WEST SUSSEX COUNTY COUNCIL CONSULTATION

TO:	Arun District Council FAO: Hebe Smith
FROM:	WSCC – Highways Authority
DATE:	24 October 2025
LOCATION:	Belle Vue Level Mare Lane Eastergate PO20 3SA
SUBJECT:	AL/95/25/PL Erection of 1 No. detached self-build dwelling and garage with parking. This application is in CIL zone 3 and is CIL liable as a new dwelling
DATE OF SITE VISIT:	n/a
RECOMMENDATION:	Advice

Proposed Plans and Elevations

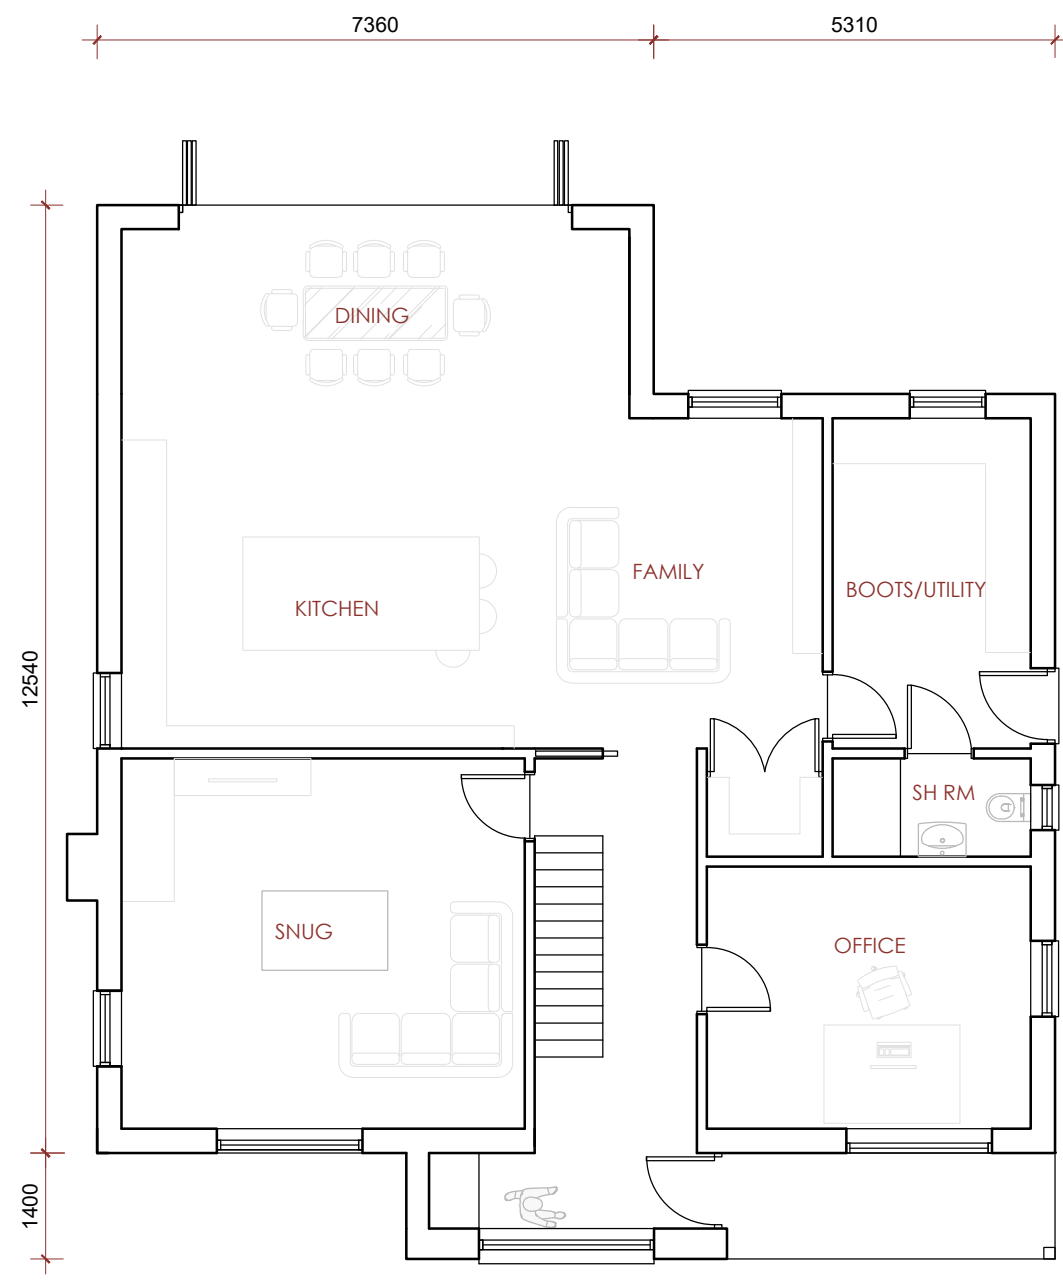
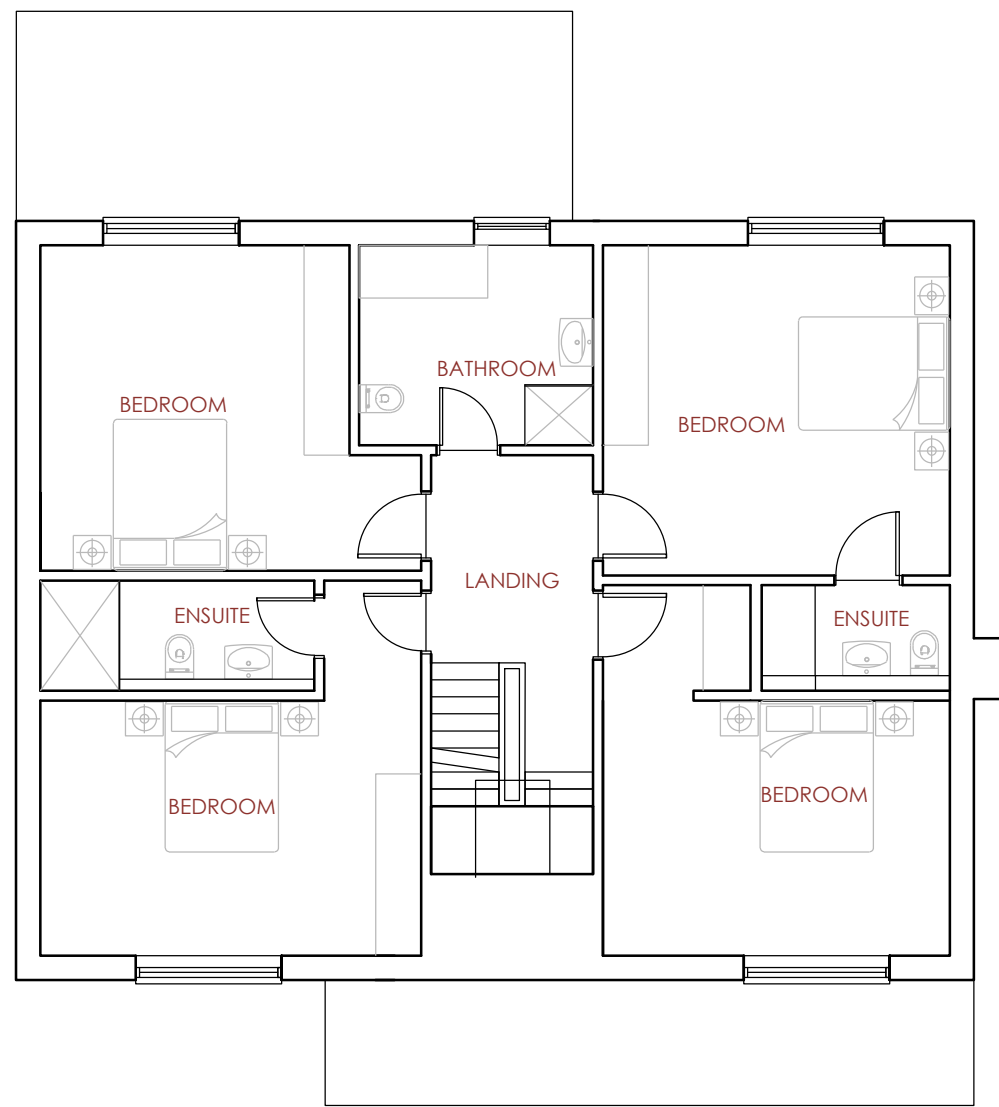
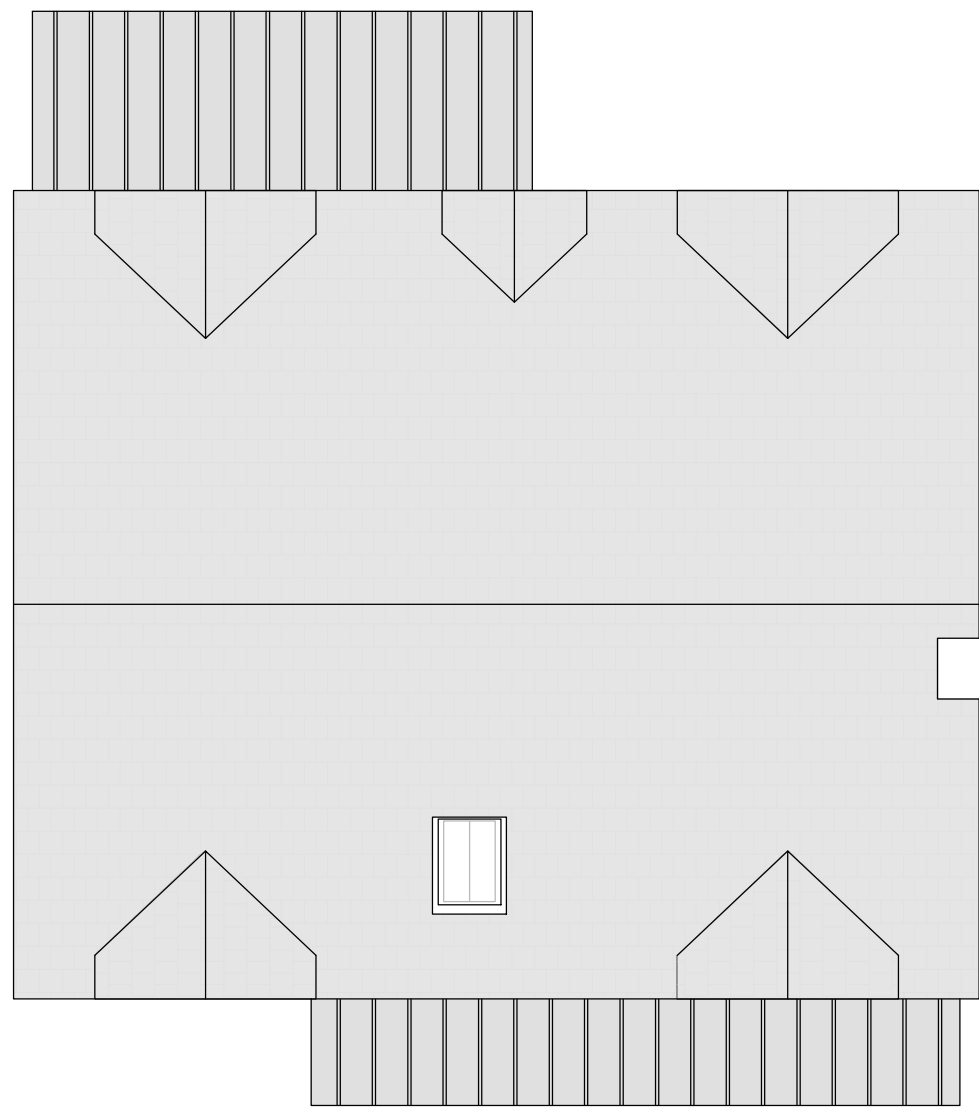
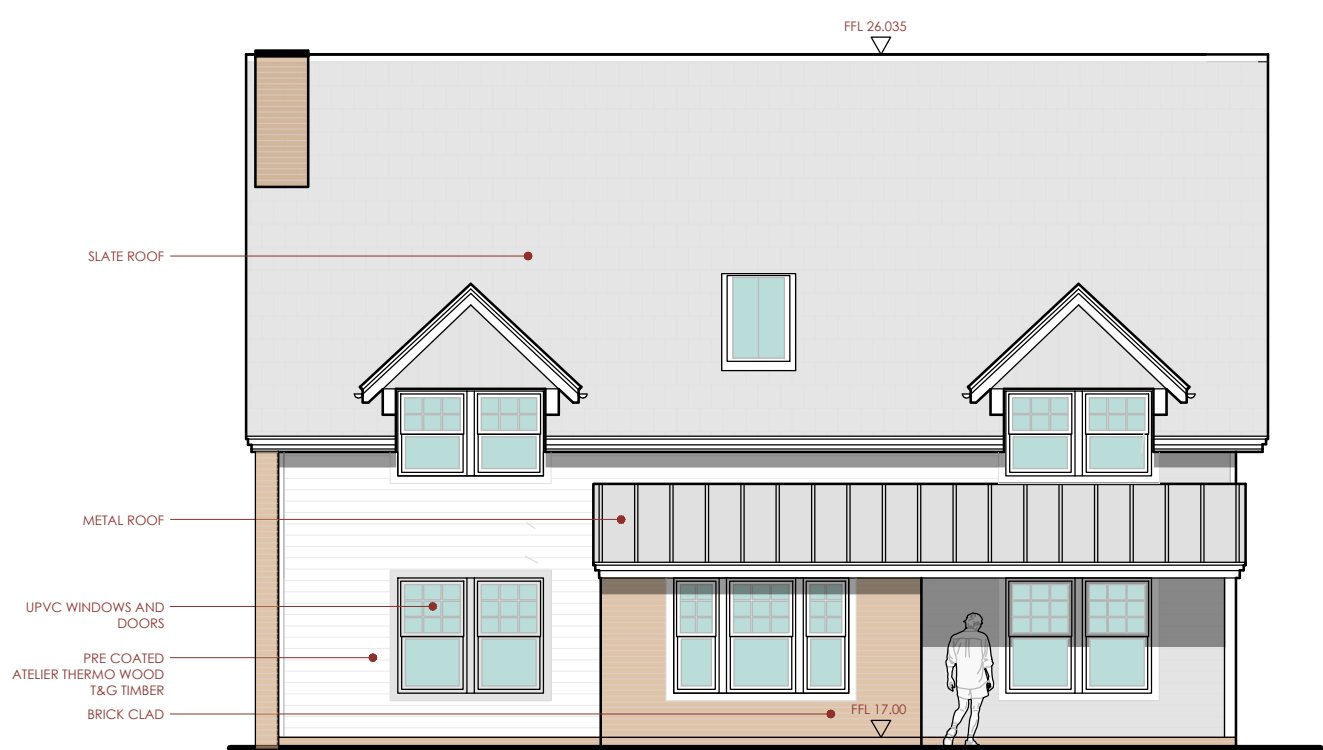
The proposed plans indicate that a double garage is to be provided on the site, the internal dimensions appear to scale off to 5.7 x 6m. WSCC car parking at new developments expects that a double garage comprise internal dimensions of 6 x 6m in order to also accommodate cycle storage for the proposed dwelling. The applicant should consider increasing the proposed garage dimensions, or provide alternative secure and covered cycle storage, to reduce the reliance upon the private car and to encourage sustainable transport options.

No part of the development shall be first occupied until covered and secure cycle parking spaces have been provided in accordance with plans and details to be submitted to and approved by the Local Planning Authority.
